Development Control
Ribblesdale Borough Council

Re: Planning Application 21/0268

Address: Land south west of Ribblesdale Hall Sawley Road Chatburn BB7 4LD

Description: Proposed change of use of agricultural land for the development of a holiday park containing 9 lodges and a managers lodge with associated access and landscaping. Resubmission of 3/2020/0307.

SHEET: **PROPOSED SITE
PLAN ENTRANCE
TRACK**

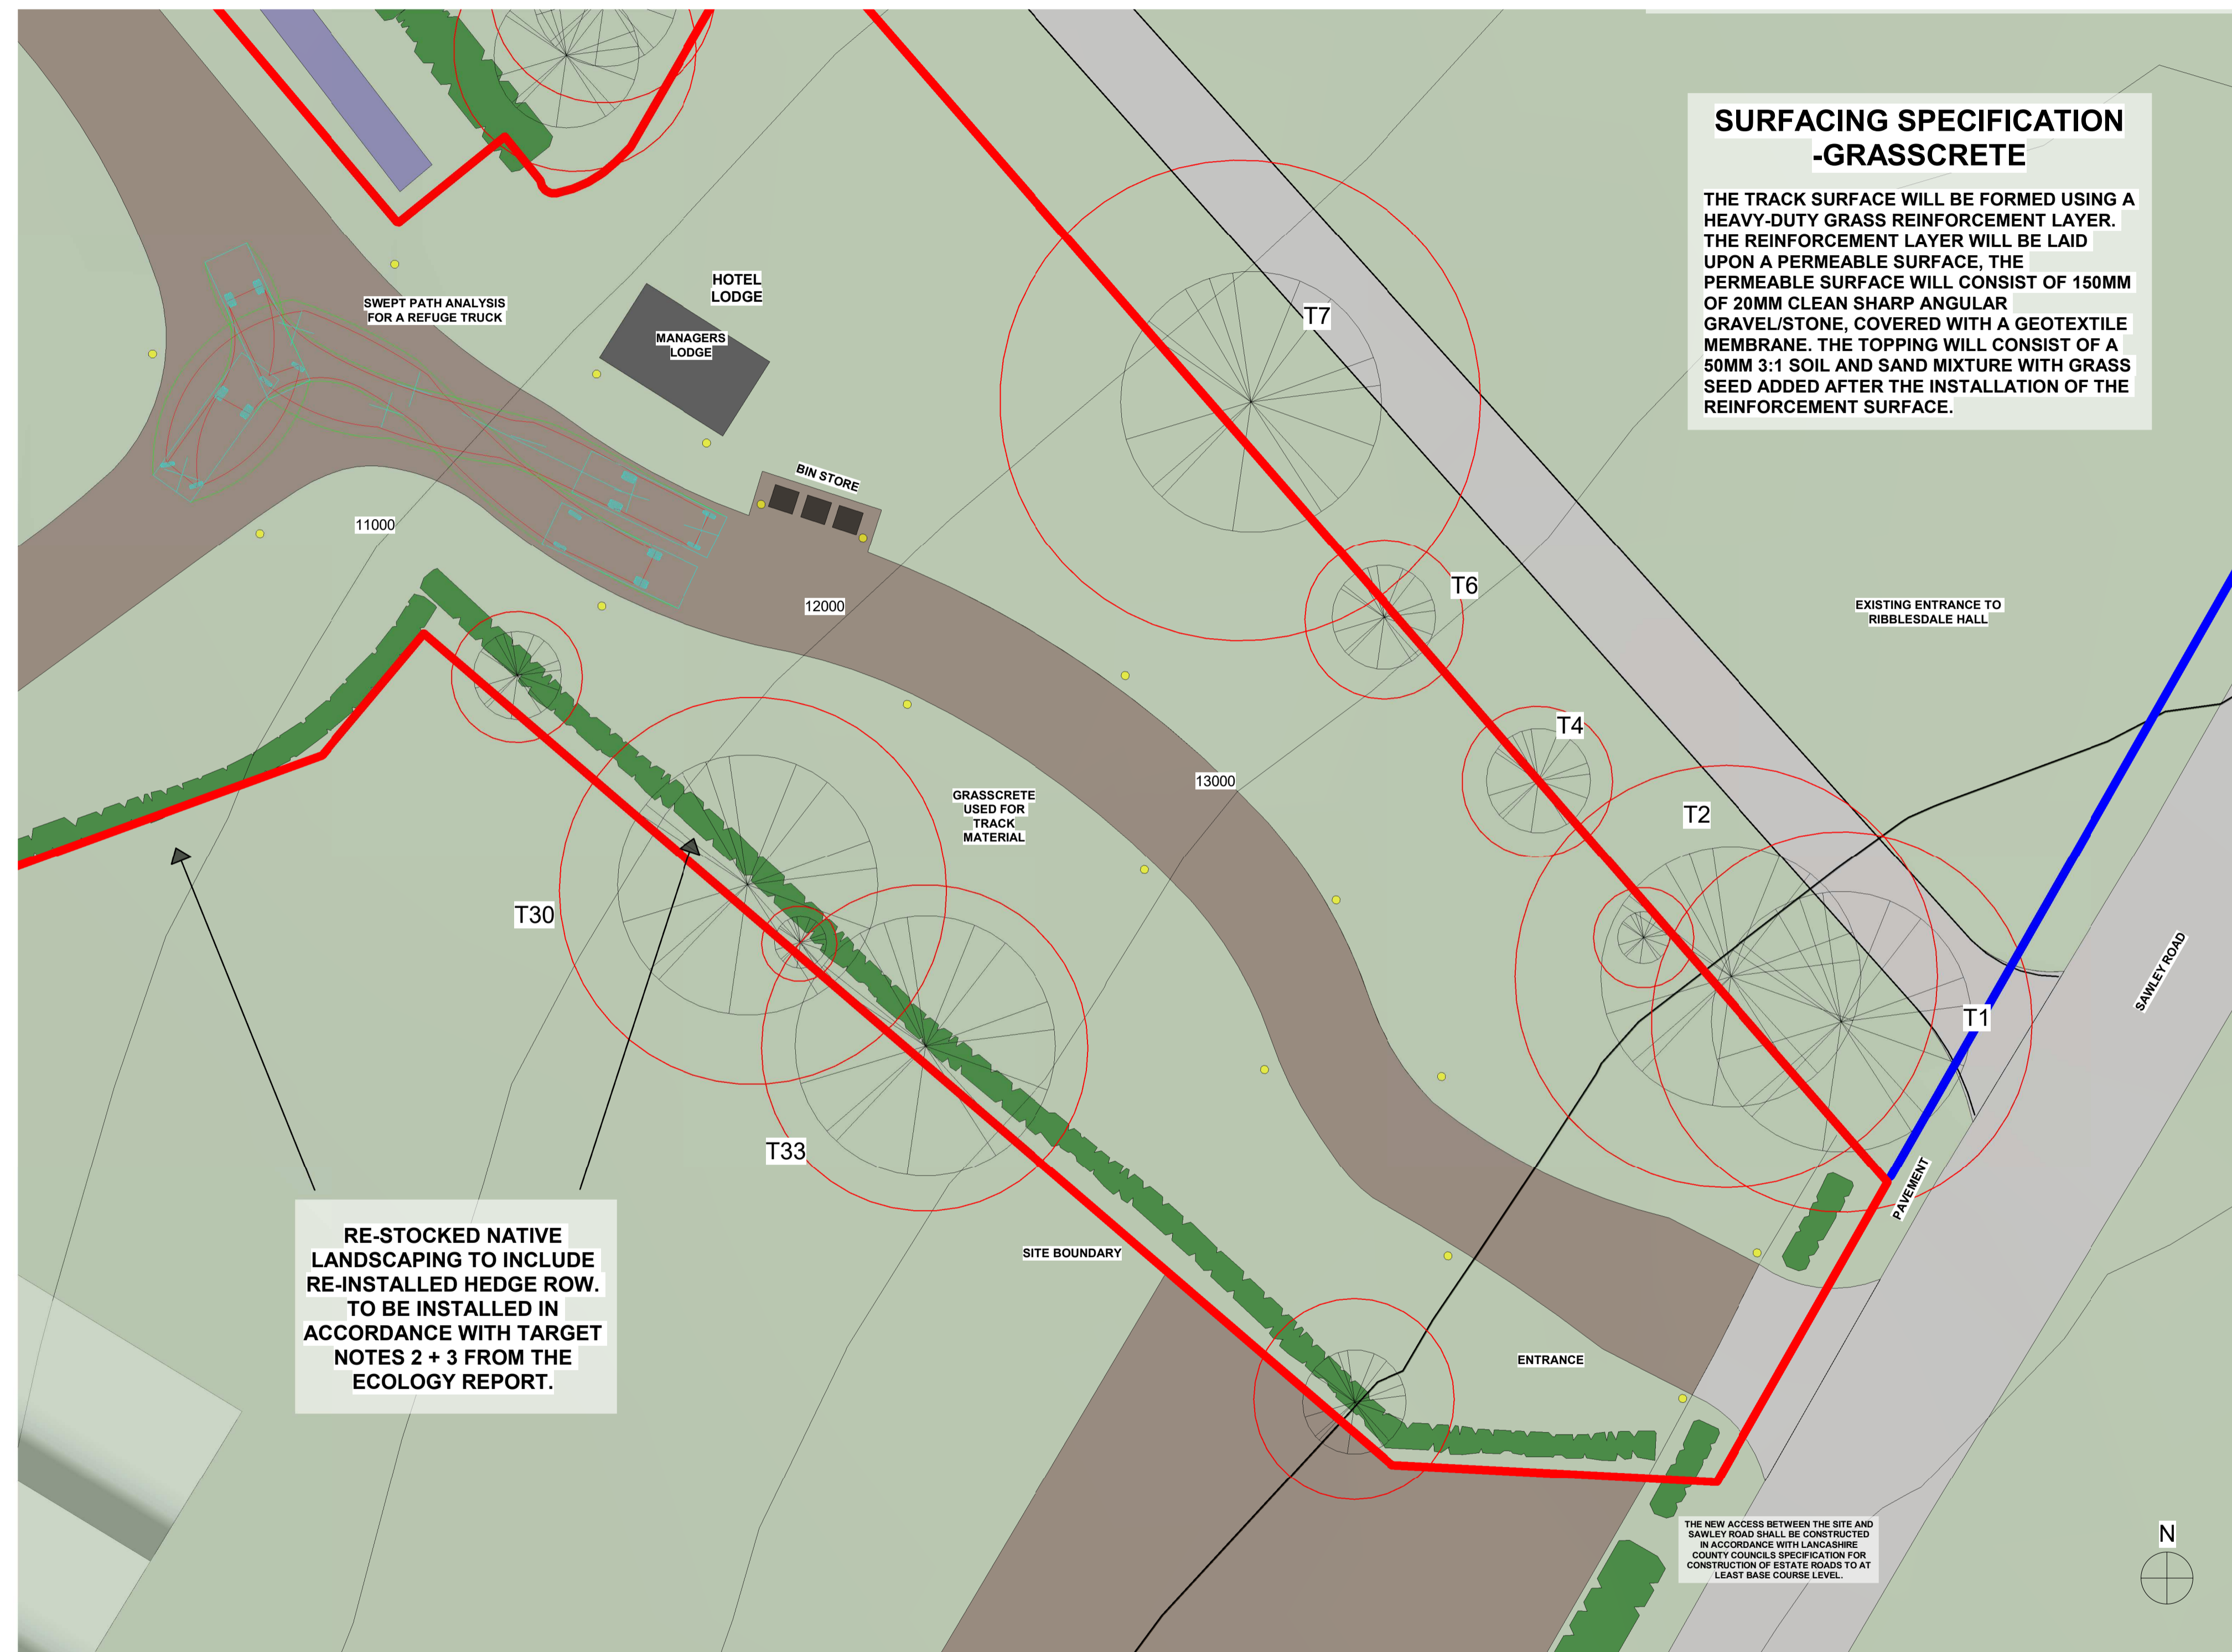
Earlier concerns regarding the access have been addressed, and it is expected that the refuse collection will be made as a kerb side collection.

The proposed access from the site to Sawley Road shall be constructed to a (minimum) width of 7 metres and this width shall be maintained for a minimum distance of 10 metres measured back from the nearside edge of Sawley Road carriageway vehicle running lanes. Reason: To enable vehicles to enter and leave the premises without conflict, unhindered & in a safe manner without causing a hazard to other road users.

Before the access is used for vehicular purposes, any gateposts erected at the access shall be positioned at least 5m behind the nearside edge of the highway and visibility splay fences or walls shall be erected from the gateposts to the existing highway boundary, such splays shall be 45° to the centre line of the access. The gates shall open away from the highway. Should the access remain un-gated 45° splays shall be provided between the highway boundary and points on either side of the drive measured 5m back from the nearside edge of the highway.

1 SITE ENTRANCE DEATIL
1 : 100

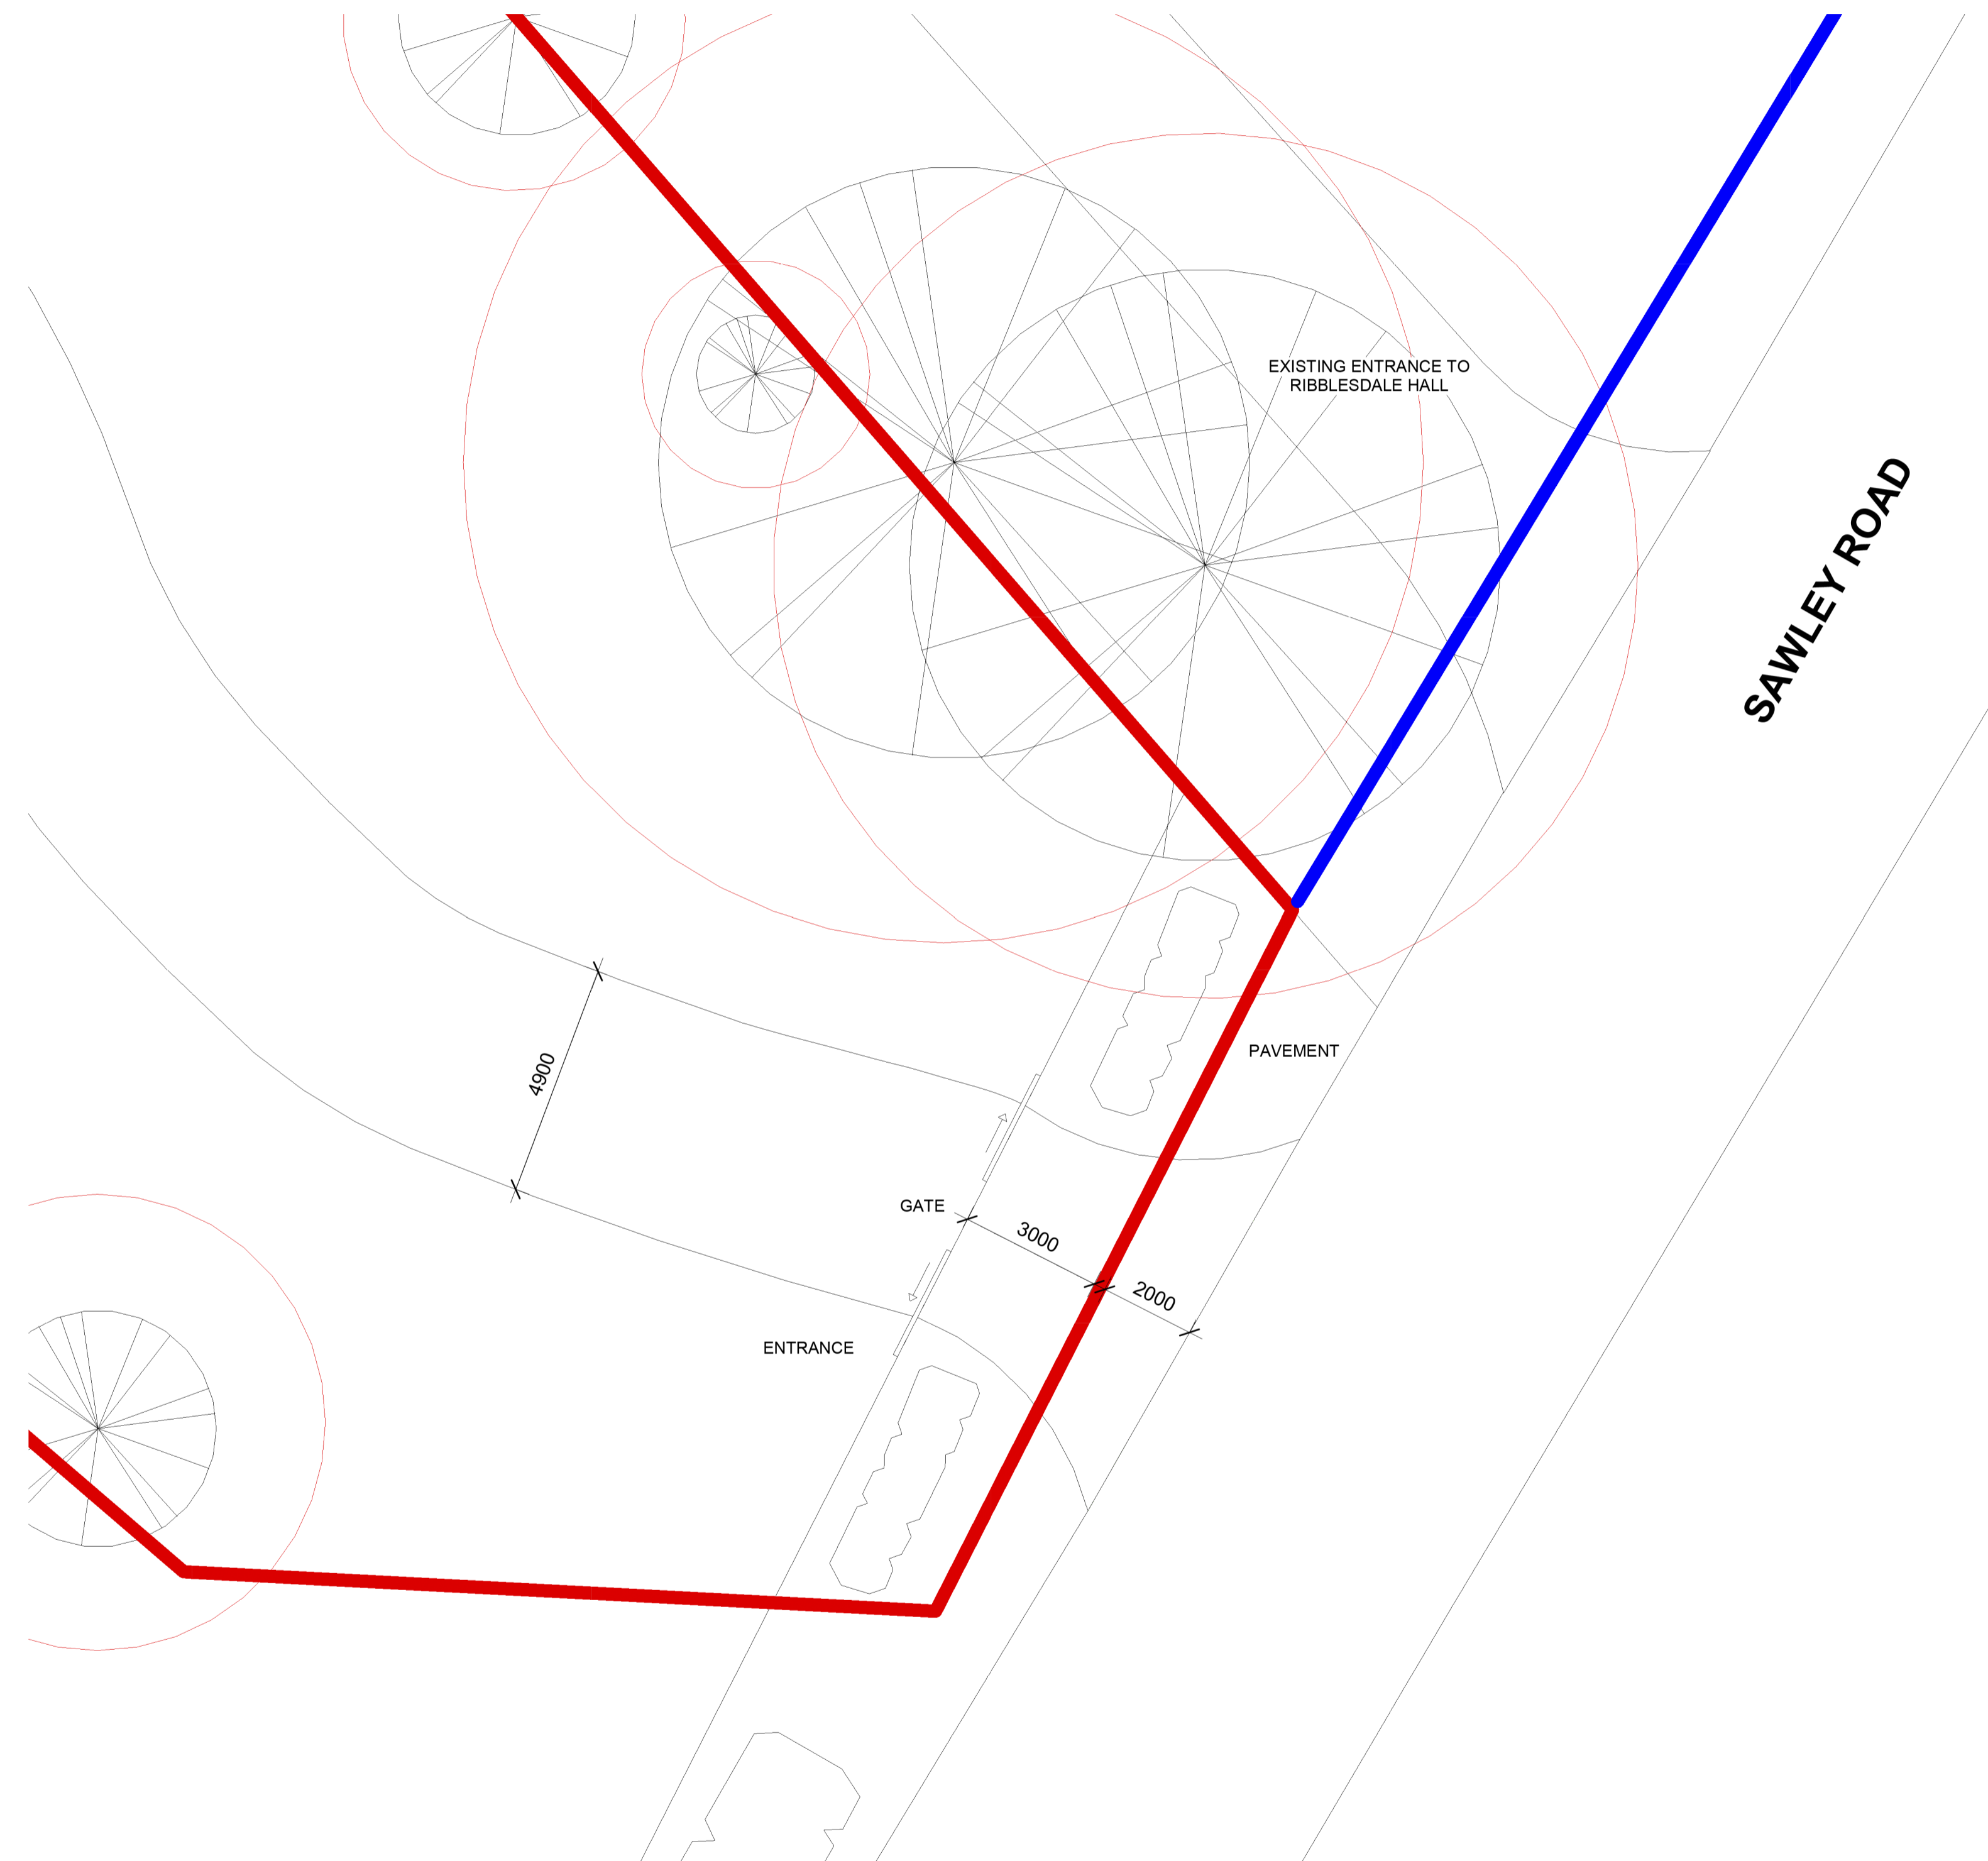
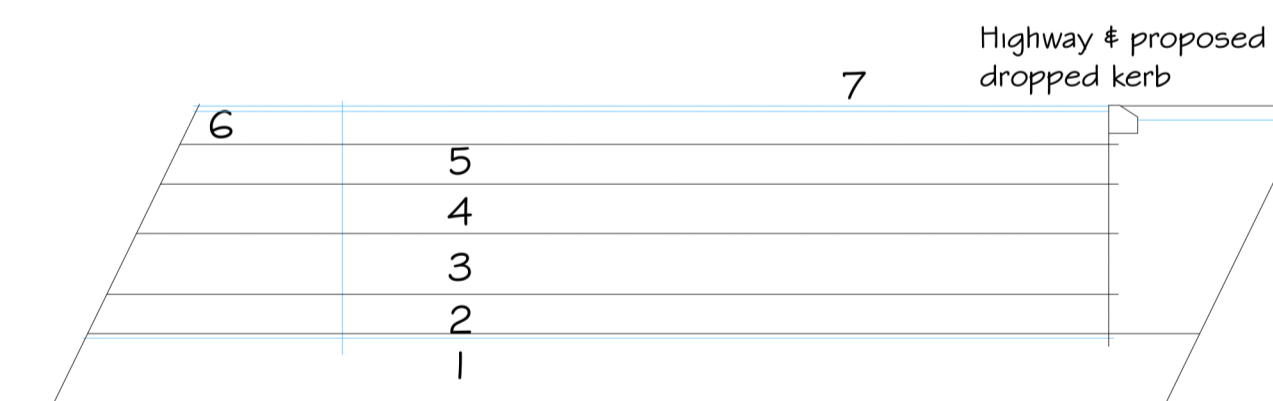
The new access between the site and Sawley Road shall be constructed in accordance with Lancashire County Council's Specification for Construction of Estate Roads to at least base course level before any development takes place within the site.
